CLAREMONT BUSINESS PARK 2 FILING NO. 1

STREET IMPROVEMENT PLANS

AUGUST 2020

EL PASO COUNTY FILE NO. PCD # SF-20-014

STORM 7
STA 1+00.00 TO STA 3+45.30
(PRIVATE)

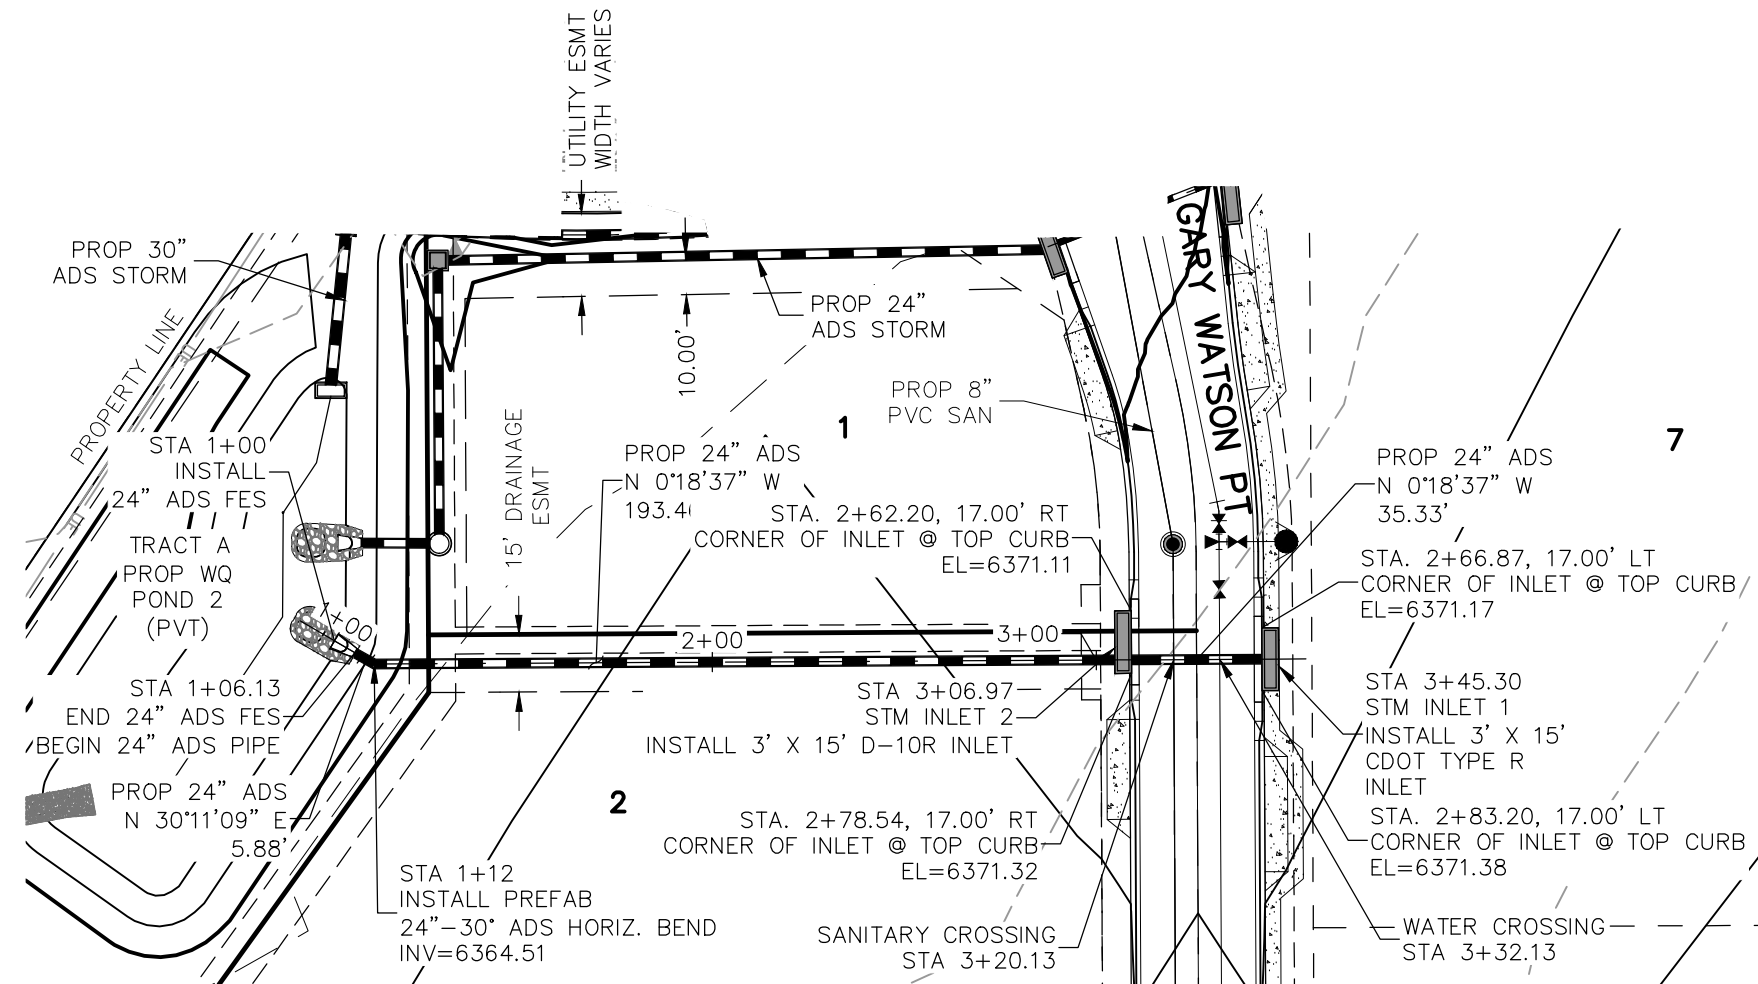
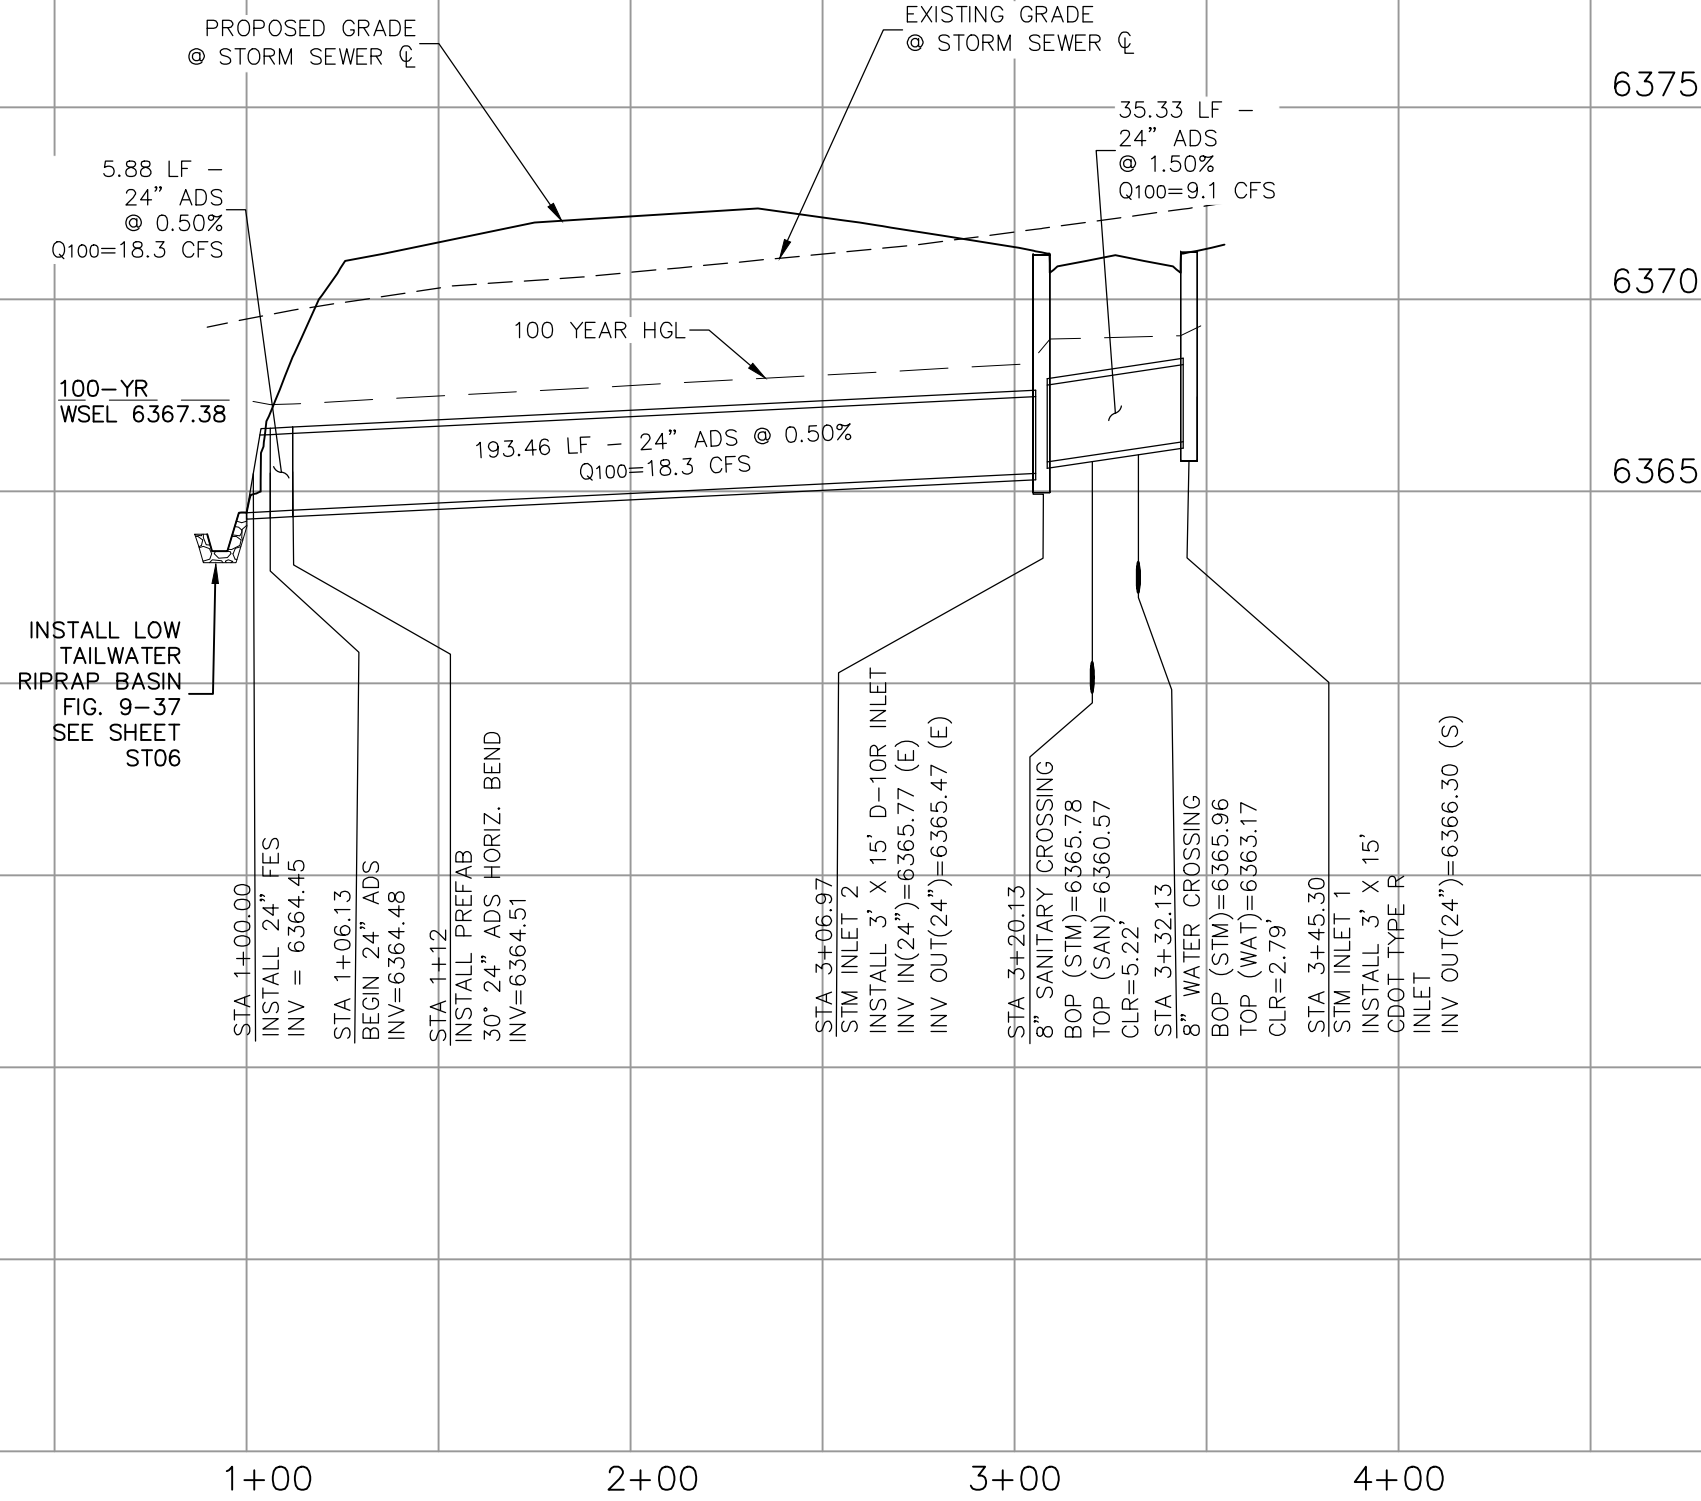
Review 1: Identify the
vertical scale
Review 2: Unresolved.
indicate the vertical scale
for the profiles below

COMMENT ADDRESSED.
VERTICAL SCALE ADDED.
